Ribble Valley Borough Council
Housing & Development Control

Application no: **3/2022/0996**

Address: **1 Holly Grove Longridge PR3 3HR**

Proposal: **Proposed two storey side extension to replace existing garage and proposed rear single storey extension.**

DWG.NO.:
2248-P01

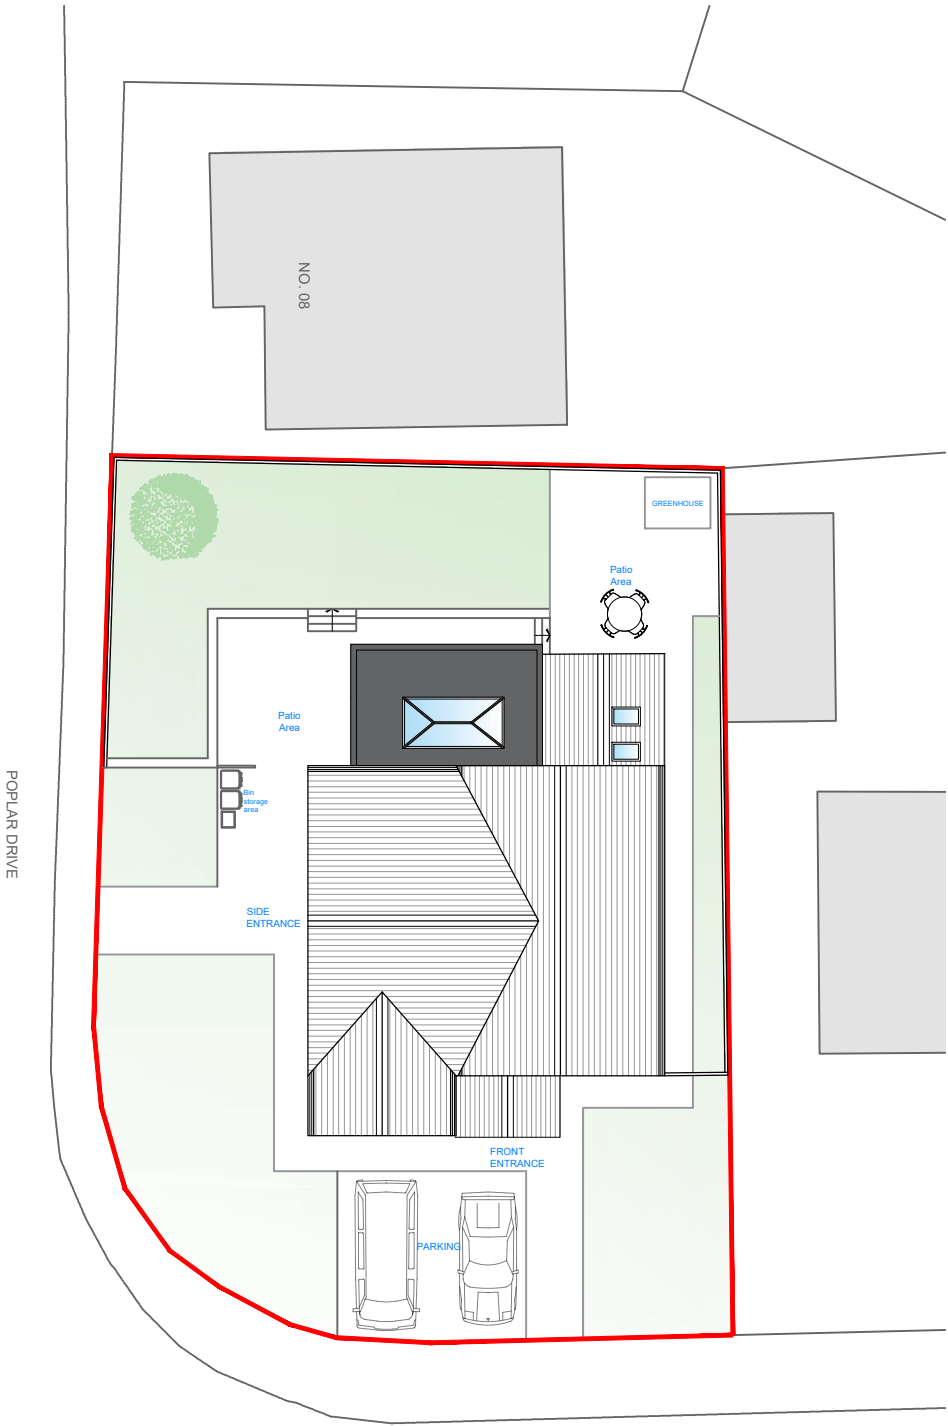
For the dwelling to comply with the LHAs parking standards as defined in the Joint Lancashire Structure Plan, the LHA require 3 car parking spaces to be provided on site. However, the dwelling can only provide 2 car parking spaces as shown on Studio John Bridge drawing number 2248-P01 titled "Existing and Proposed Site Plans." Therefore, there is a shortfall of one car parking space at the site.

As a result of the shortfall, the LHA require the access and the existing driveway to be extended to provide the additional car parking space. The LHA have reviewed Studio John Bridge drawing number 2248-P01 and are aware that there is the adequate space to provide the additional car parking space. Therefore, a revised drawing is required to show the amendments.
